HERTFORDSHIRE ECOLOGY

Application Reference: 6/2017/2625/COND

Proposed development at: Plot 4100 Gypsy Moth Avenue Hatfield Business Park Hatfield
Proposal: Submission of details pursuant to conditions: 5 (details of new roads, accesses, cycleways and footpaths), 6 (Surface water drainage scheme), 7 (site investigation), 9 (Reptile Survey), 12 (details of floor lighting and external lighting) and 13 (details of open storage) on planning permission 6/2015/2043/OUTLINE dated 05/07/16

## Exterior Scene 1 / False Colour Rendering

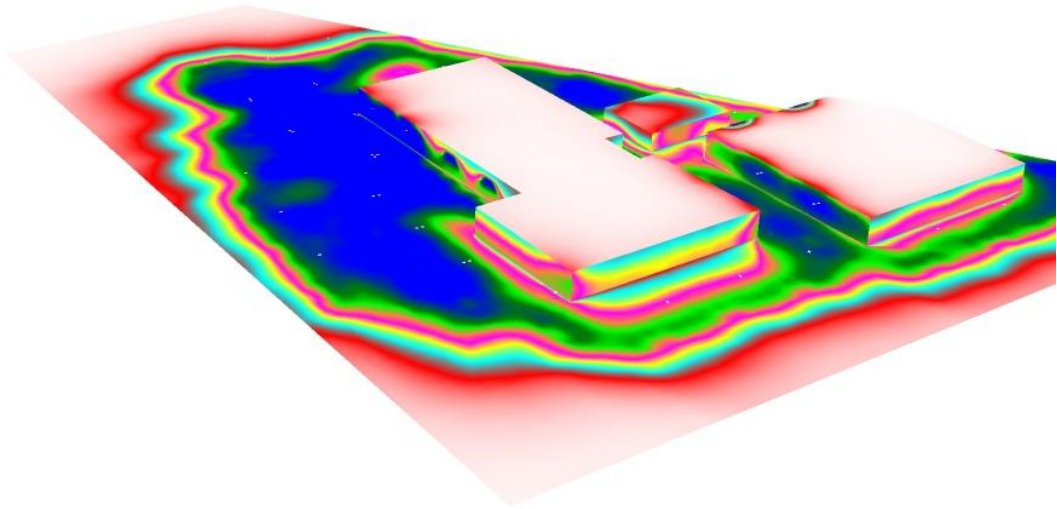
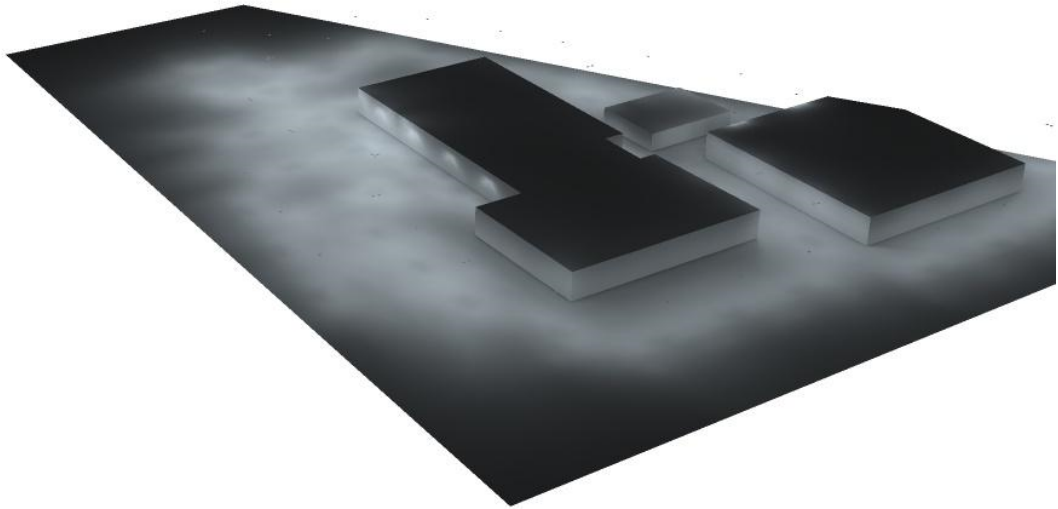
I have seen the External Lighting details submitted in support of Condition 12. I am pleased to see the use of downward pointing LED lights, which will reduce impact to wildlife and sky glare.
